Mr Andrew Lewis
Planning Officer Cherwell District Council
Bodicote House
Bodicote
Banbury
Oxfordshire OX15 4AA

17th September 2020

Amended Response to Traffic Proposals - Heyford Park

WALKING AND CYCLING STRATEGY

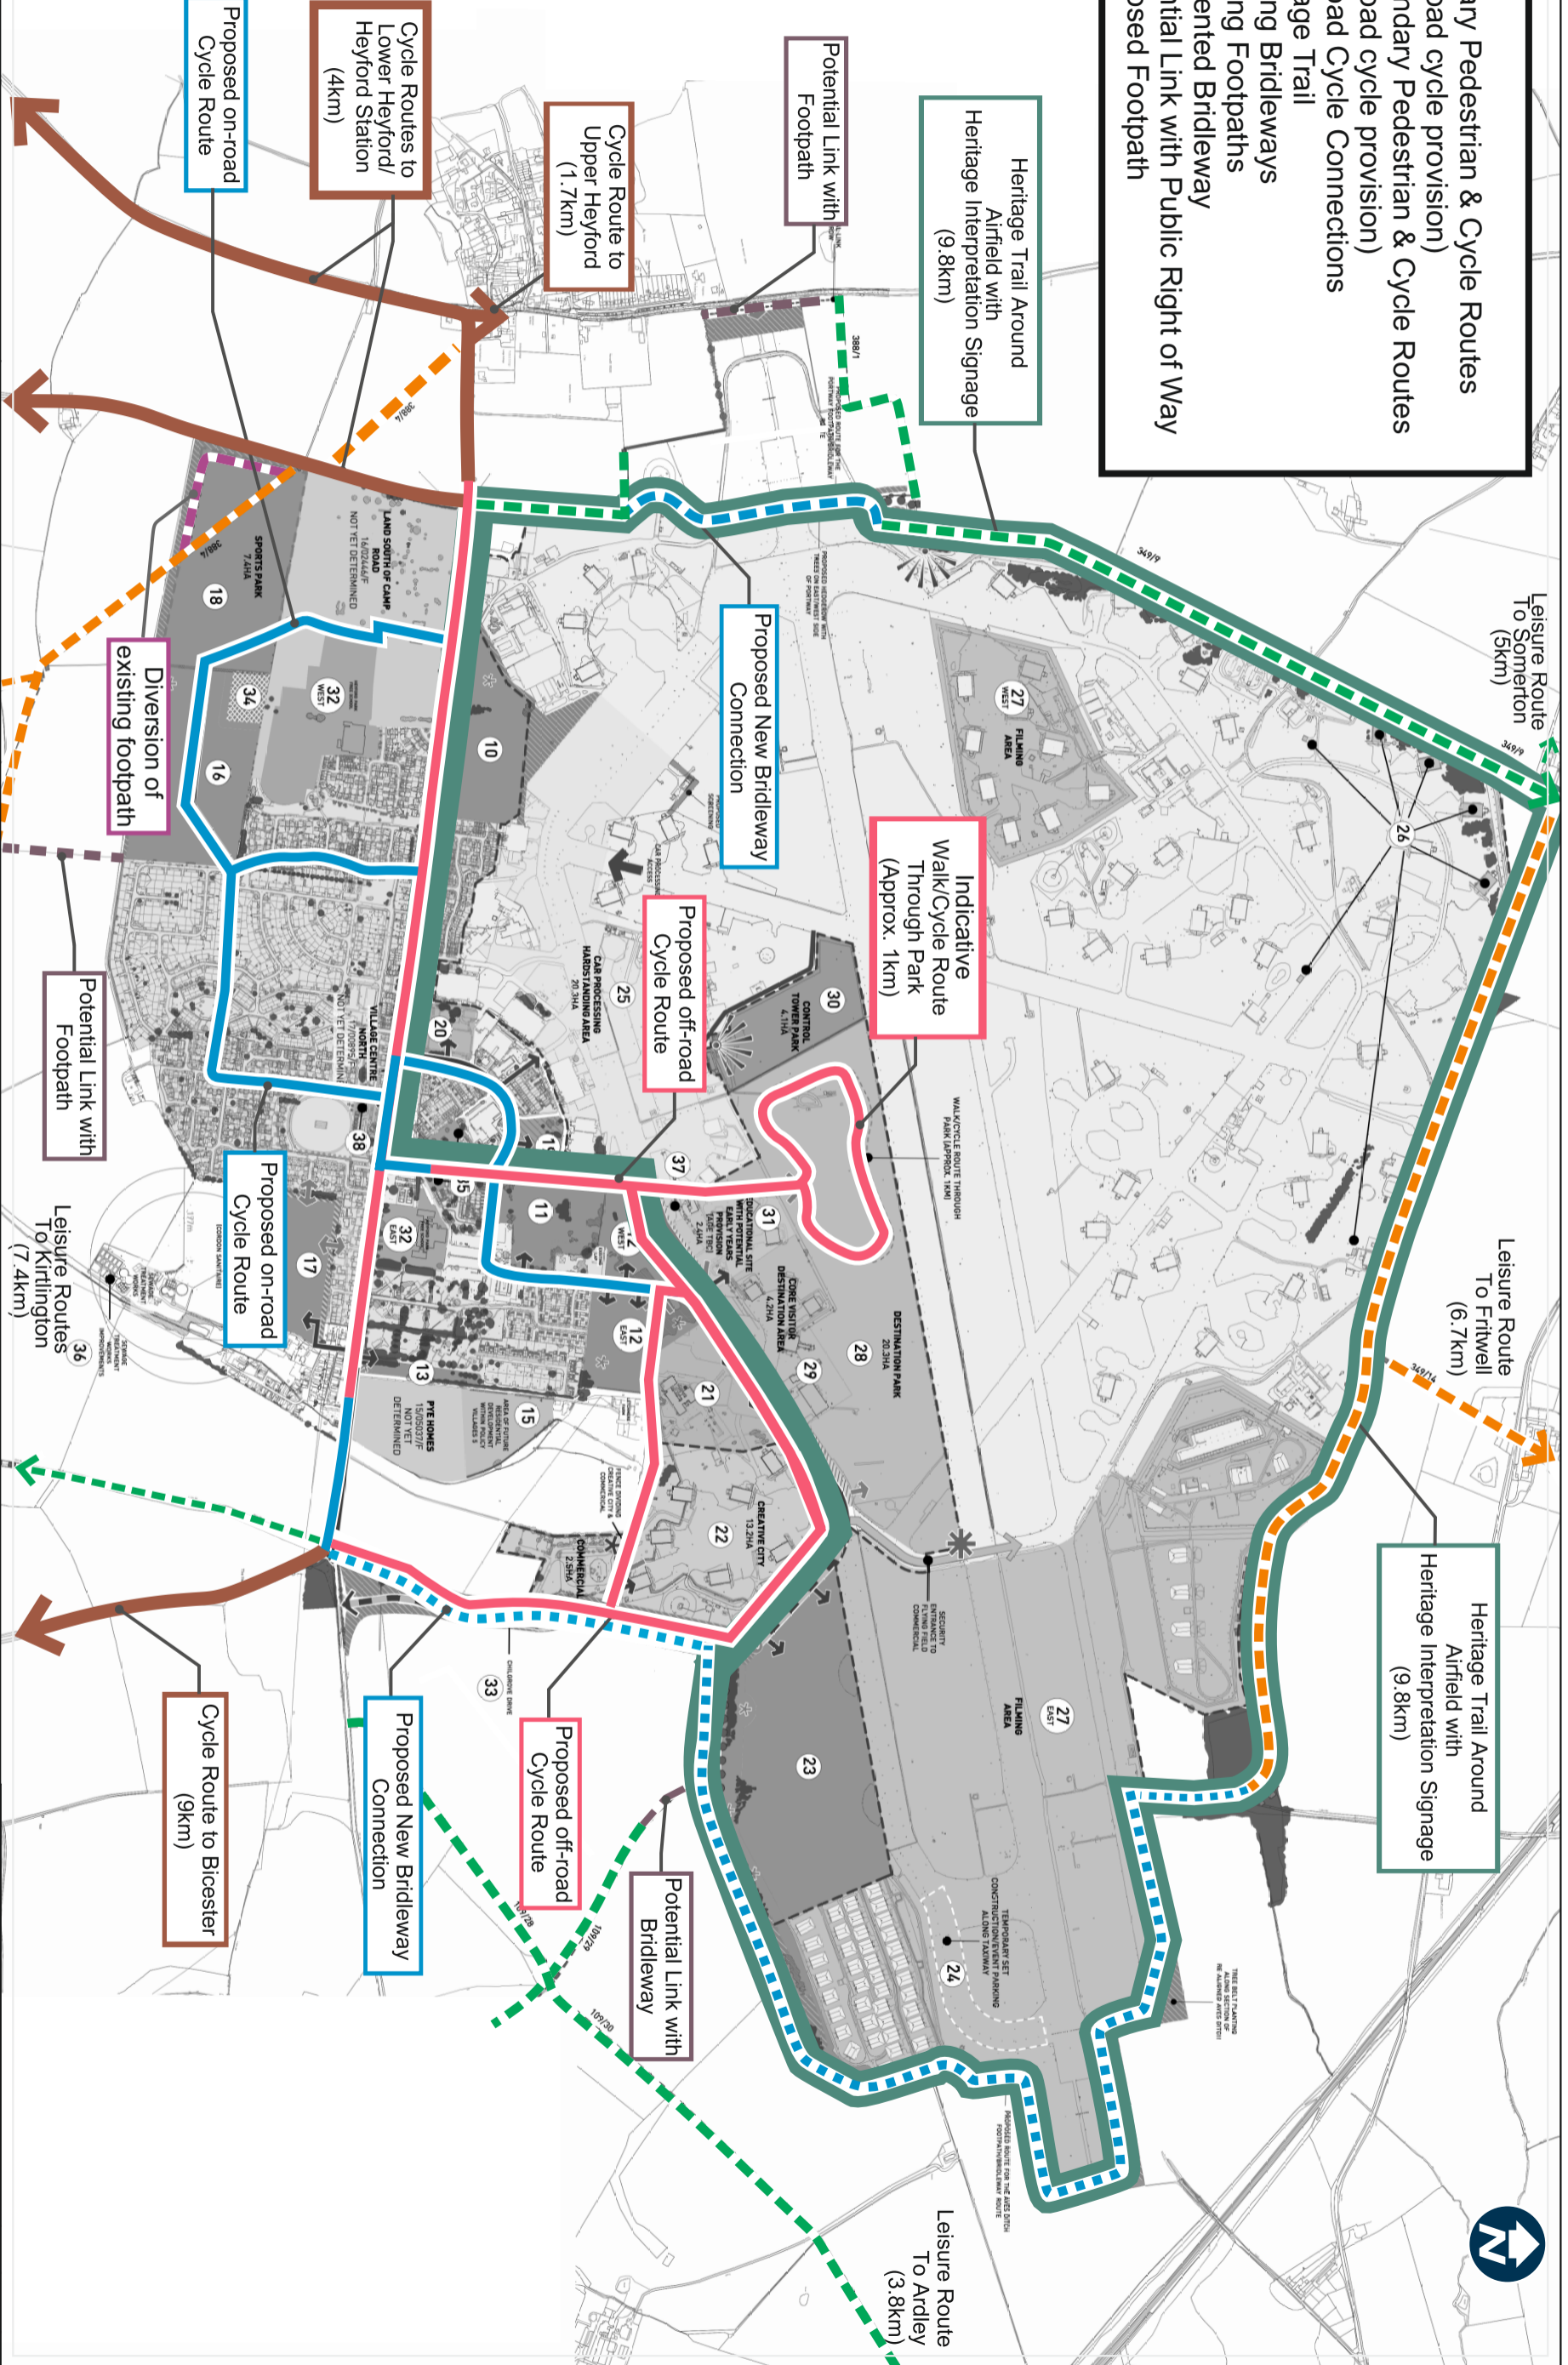
- This is a missed opportunity – an off-road cycle route to Bicester is required. This is demonstrated with the planned off-road route planned between Middleton Stoney and Bicester but will not be properly utilised if cyclists are then forced onto main roads with painted lanes.

SCALE	1:200 @ A0	DATE	JULY 2020
DRAWN	NK	CHK	JGF
DRAWING NO.	16871-SK380	REV	B
TITLE	CAMP ROAD UPPER HEYFORD		
DETAILS	POSSIBLE FOOTPATH SECTION 278 WORKS ON CAMP ROAD EAST

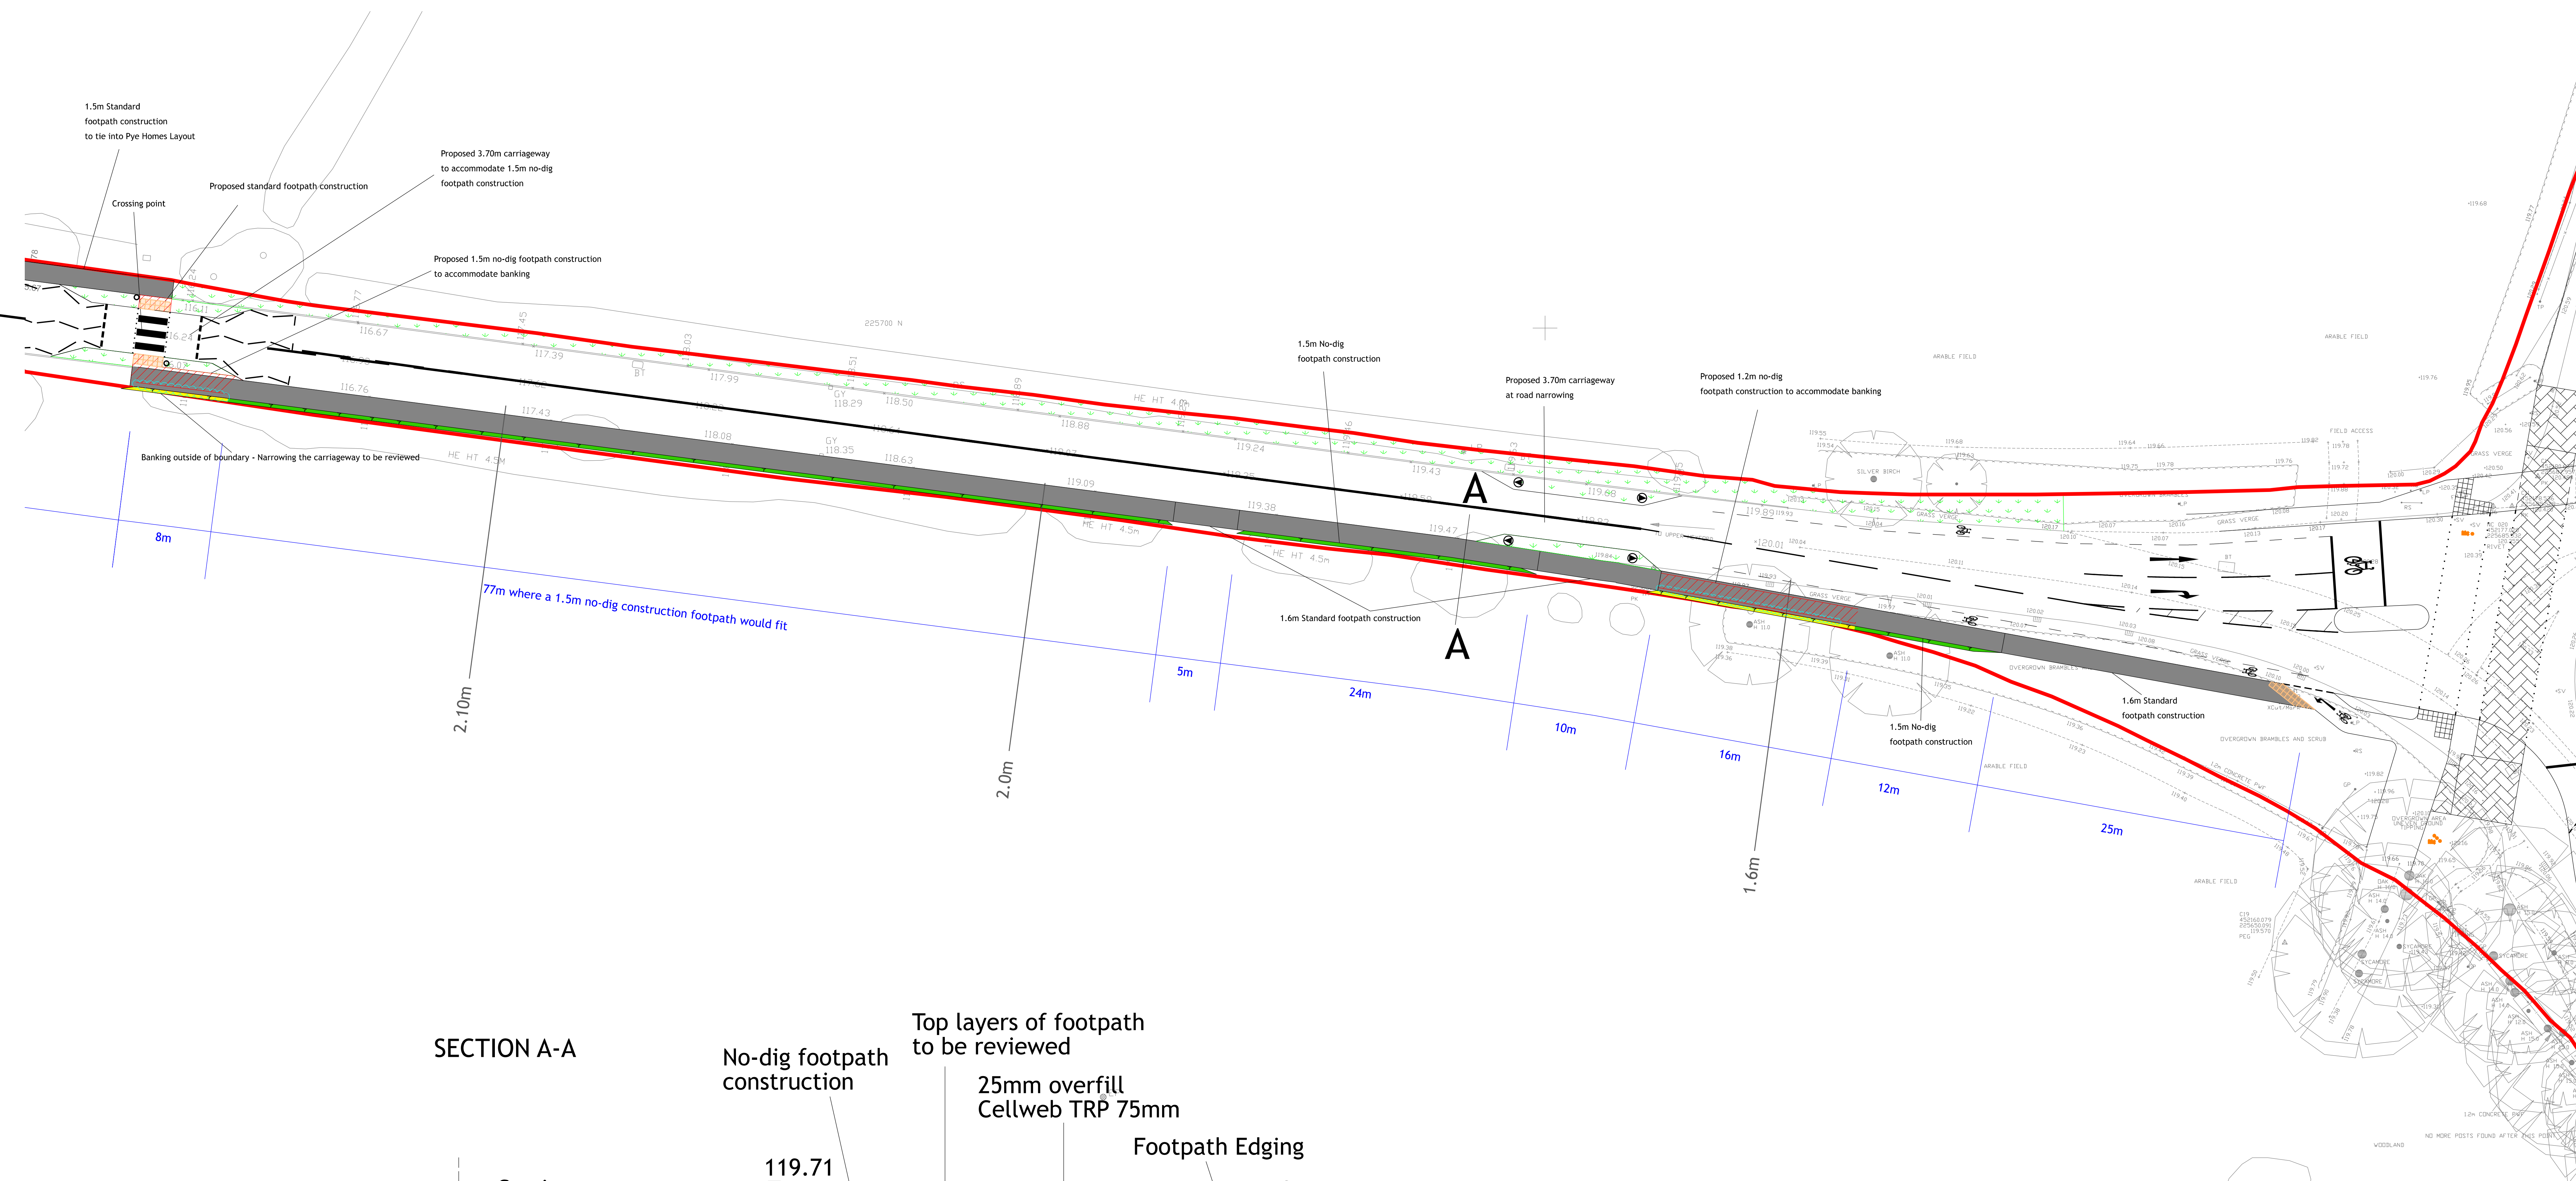
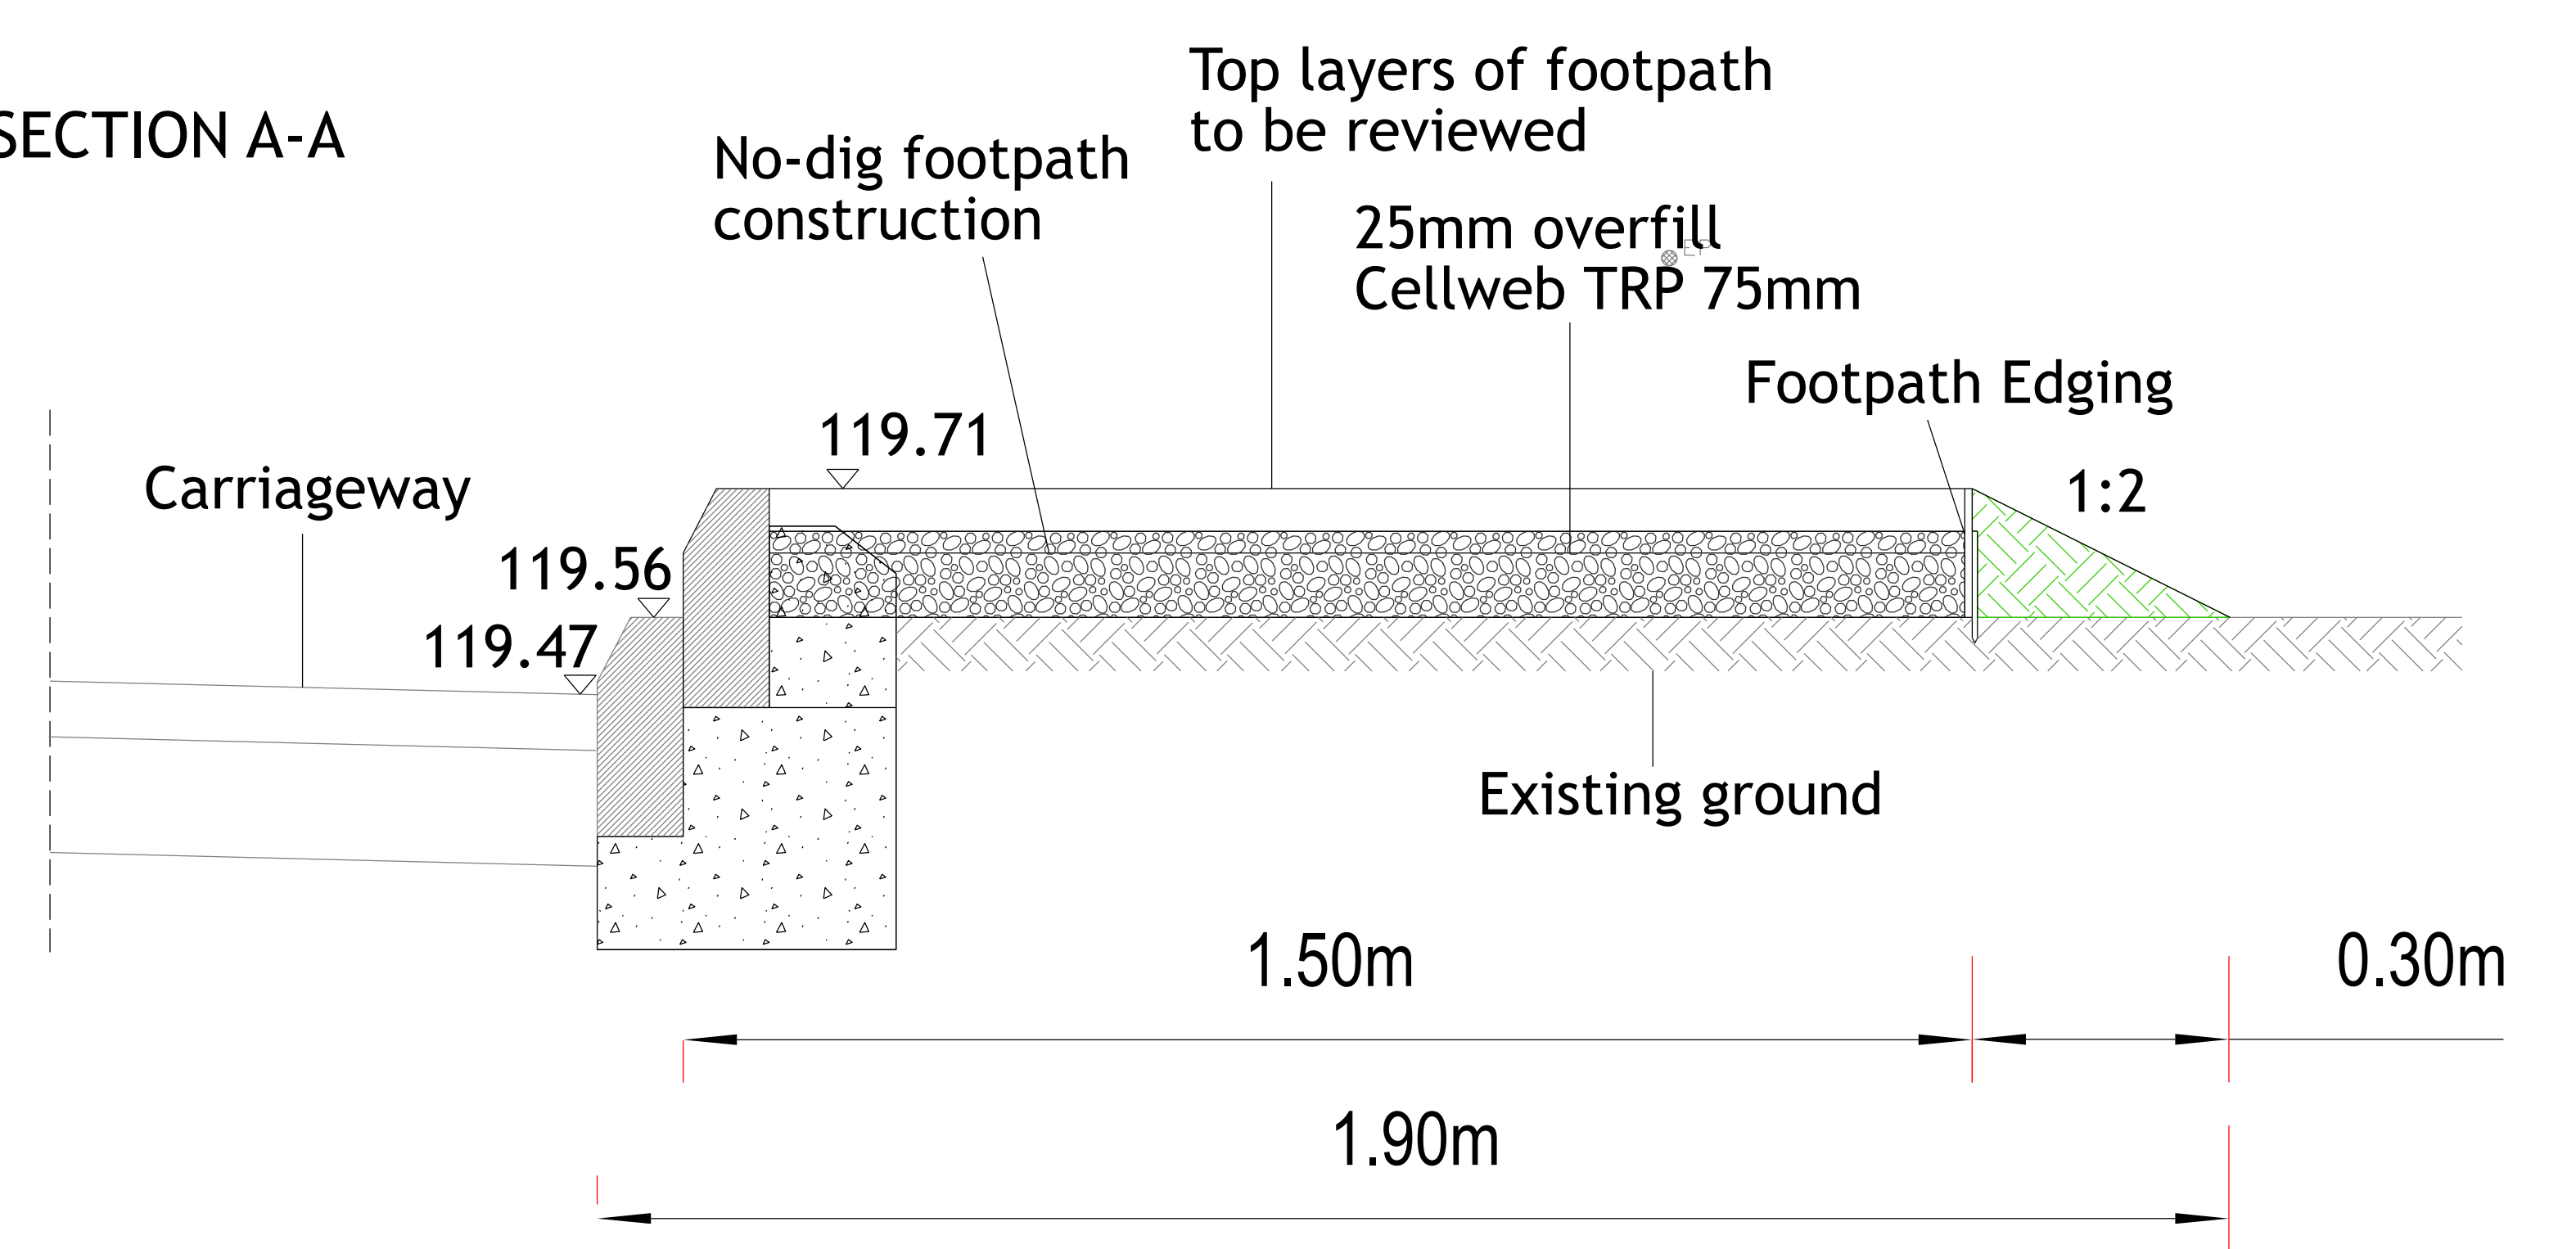
- A mixed on-off cycle route will not encourage more people to cycle so offers no real benefit. The transport strategy should have healthy, environmentally friendly methods of transport like cycling at its core.

- The inclusion of on-road cycle lanes will put off families as they will not want their children to use them.
 - UK Cycling Commissioners have written to the Government stating painted lanes make people feel “less safe”, are a “gesture” and a “waste of money”.
